Your Ref: OWPC18055
Our Ref: EP/44/18/HH 15-03-2018
Please ask for:
Andrew Wood

Hip to gable loft conversion
2 Hillview Crescent East Preston

Thank you for your internet representation made on 1st May 2018 which has been recorded as '**an objection**' with the comments as follows:

DRAWING
PLANNING
DATE: JULY 2017
DRAWN: T. Murray
DRAWING: 11/21/16

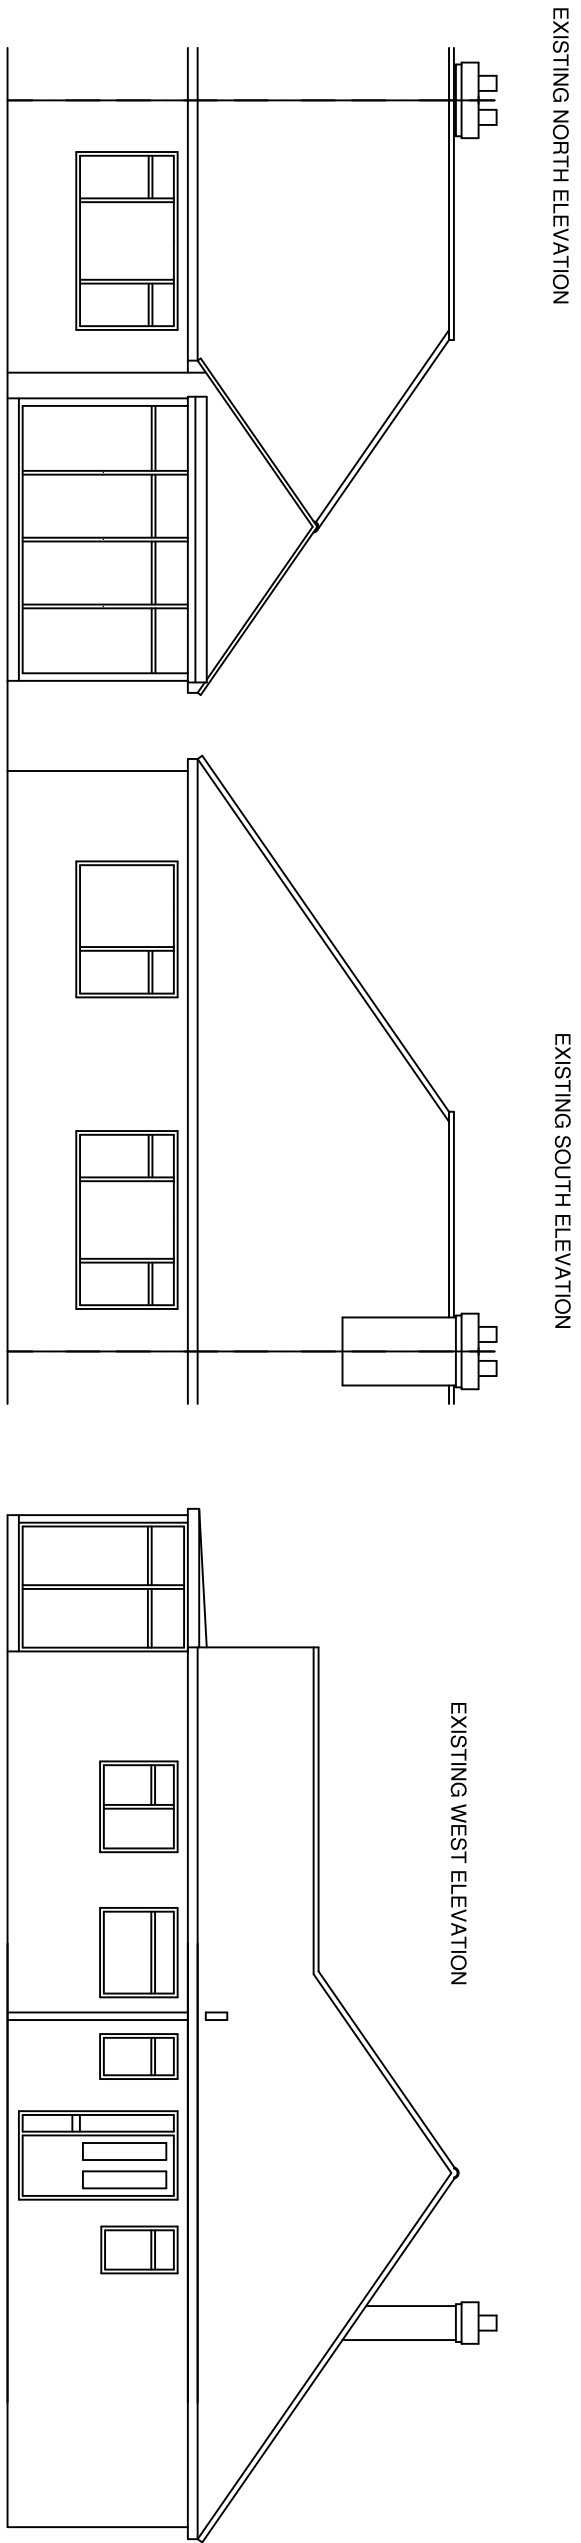
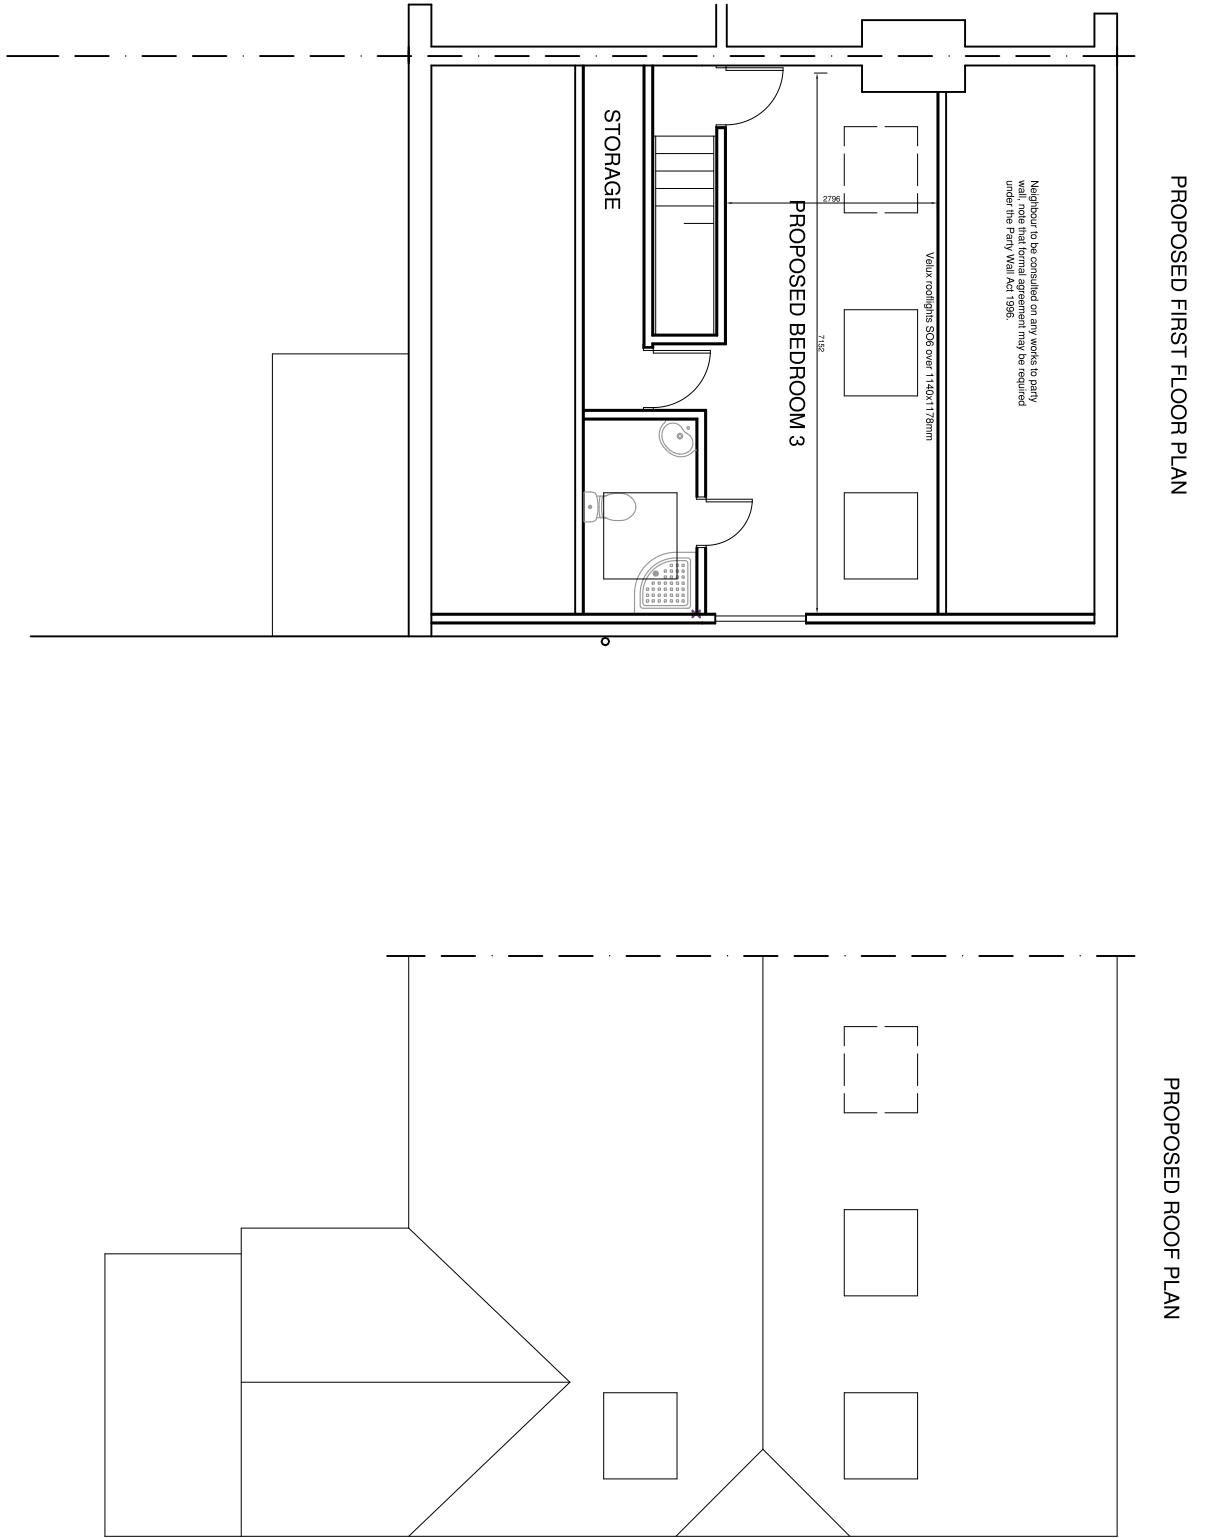
The proposed alterations to this house closely resemble those applied for under EP/150/17, for which permission was recently refused. The large increase in the mass of the roof created by the alteration from hip to bonnet gable is retained from EP/150/17. This feature was the prime reason for the rejection of that application, because the enlarged roof would dominate the existing building and conflict with the existing character of that building and of the wider neighbourhood.

The Officer's Report said that "The proposal will unbalance the property and have an unacceptable adverse impact on the established character and appearance of the host dwelling and the wider area, which primarily retains the symmetry of the roofs of the semi-detached properties". This is indeed an area in which the original appearance of the bungalows has been preserved and ought to be protected. 2 Hillview Crescent, being a corner property, is one in which the proposed changes would be especially conspicuous and therefore especially damaging to the character of the area.

The proposal is contrary to Policies GEN7 and DEV19 of the Arun Local Plan and to Policies 1 and 3 of the East Preston Neighbourhood Plan. We therefore trust that this application will be refused.
